From: Lucy Walker
Sent: 23 April 2024 08:14
To: Planning
Subject: FW: 915810 Longridge High School Preston Road Longridge Preston PR3 3AR

I have looked at the drawings supplied showing proposals for new vehicular access off Little Lane at Longridge High School .

Highway Details

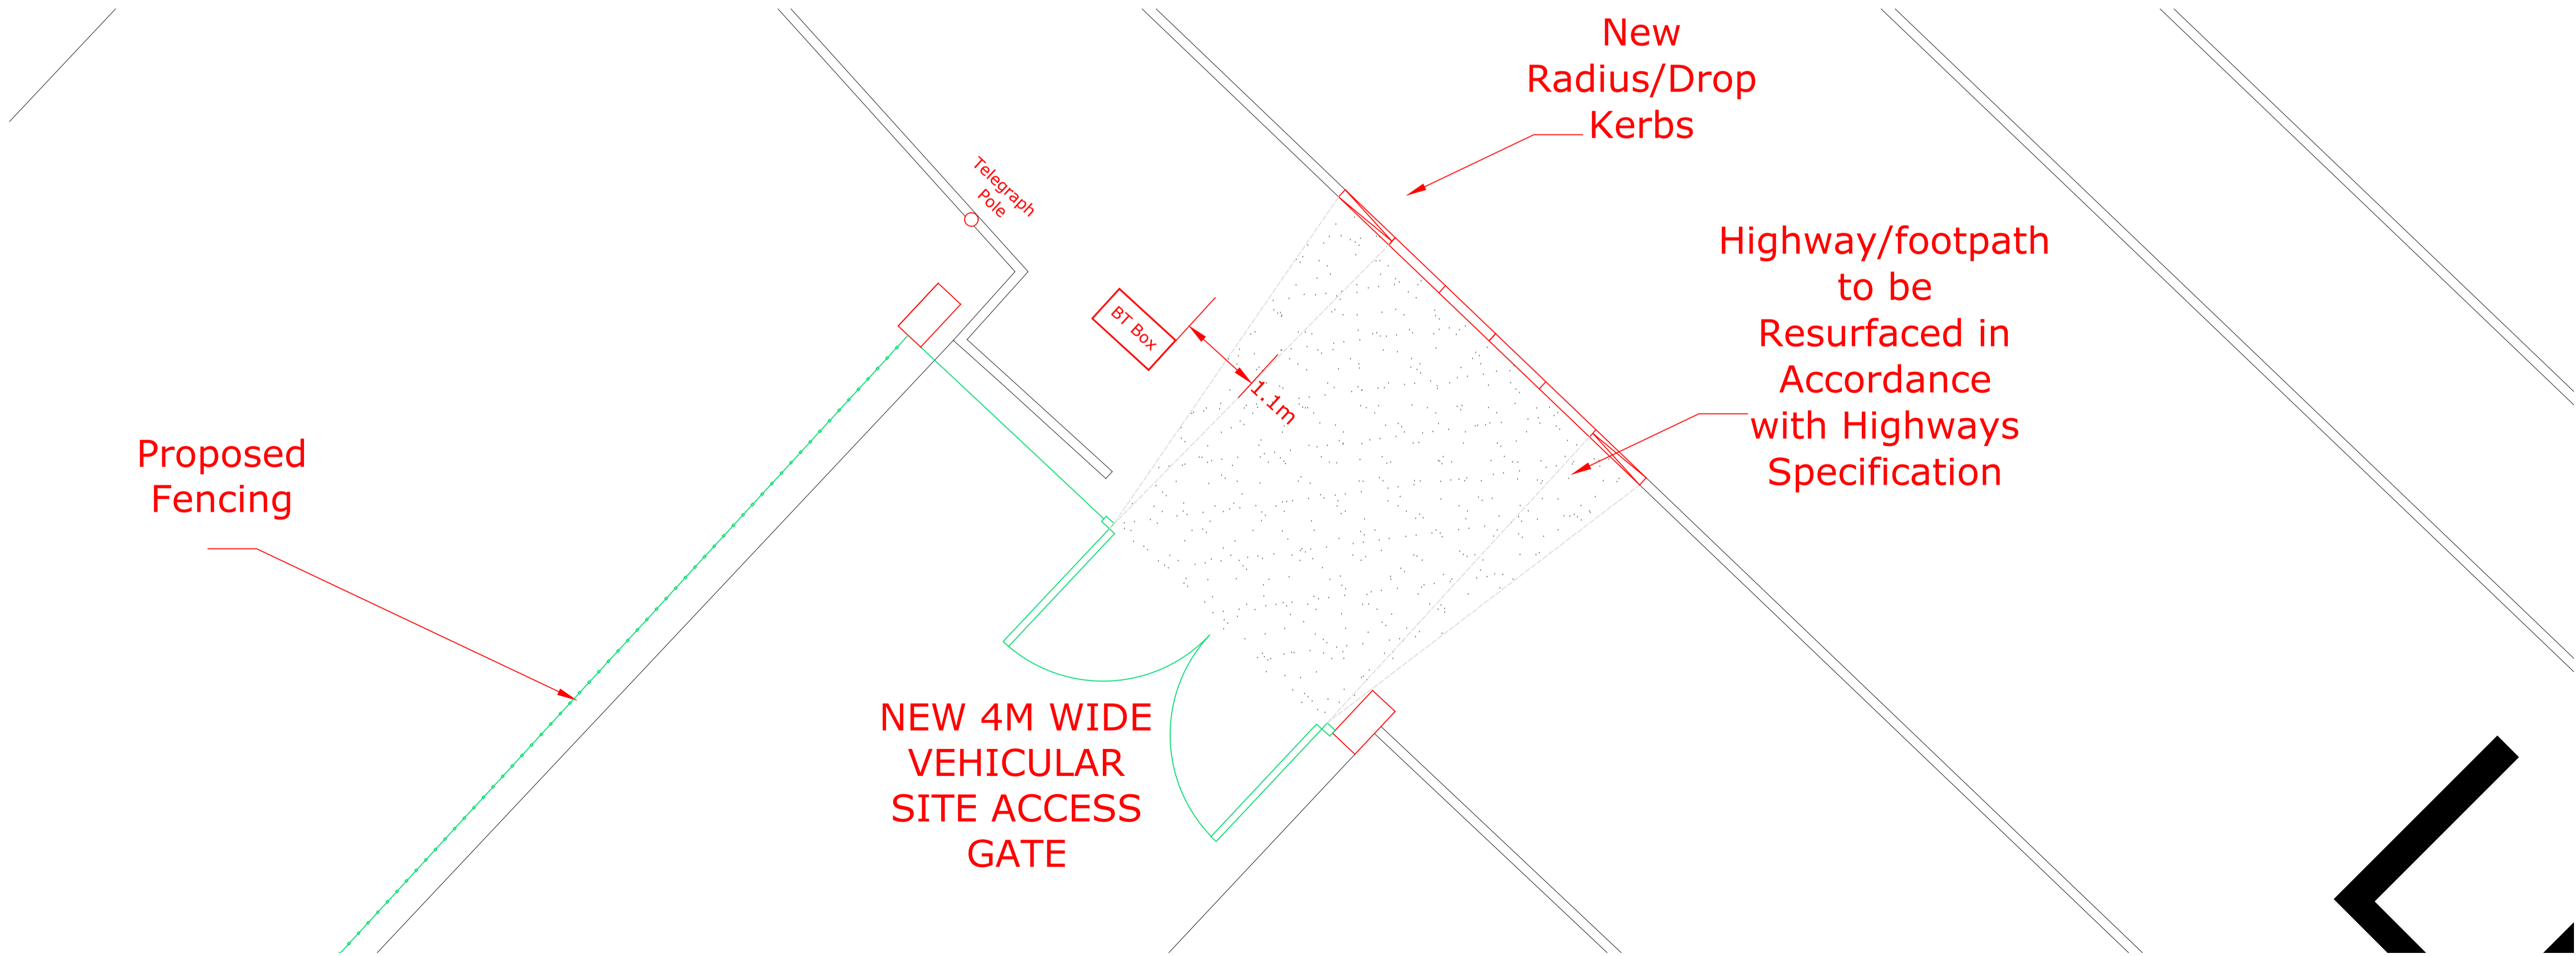
Openreach have an asset in the footway as part of the dropped kerb proposals .This footway chamber can support vehicular access and is rated accordingly .As the plans stand Openreach are happy that the proposed plans require no additional protection , diversion or alteration measures by Openreach.

If the proposals were to change for a carriage way entrance where the access road is tied into the existing carriage way levels then Openreach would need alter and divert its duct and cables which is chargeable works.

We also have two wooden telegraph poles in the vicinity of the works and if works progress as per the proposed plans we Openreach do not have any objections to them remaining as they are .
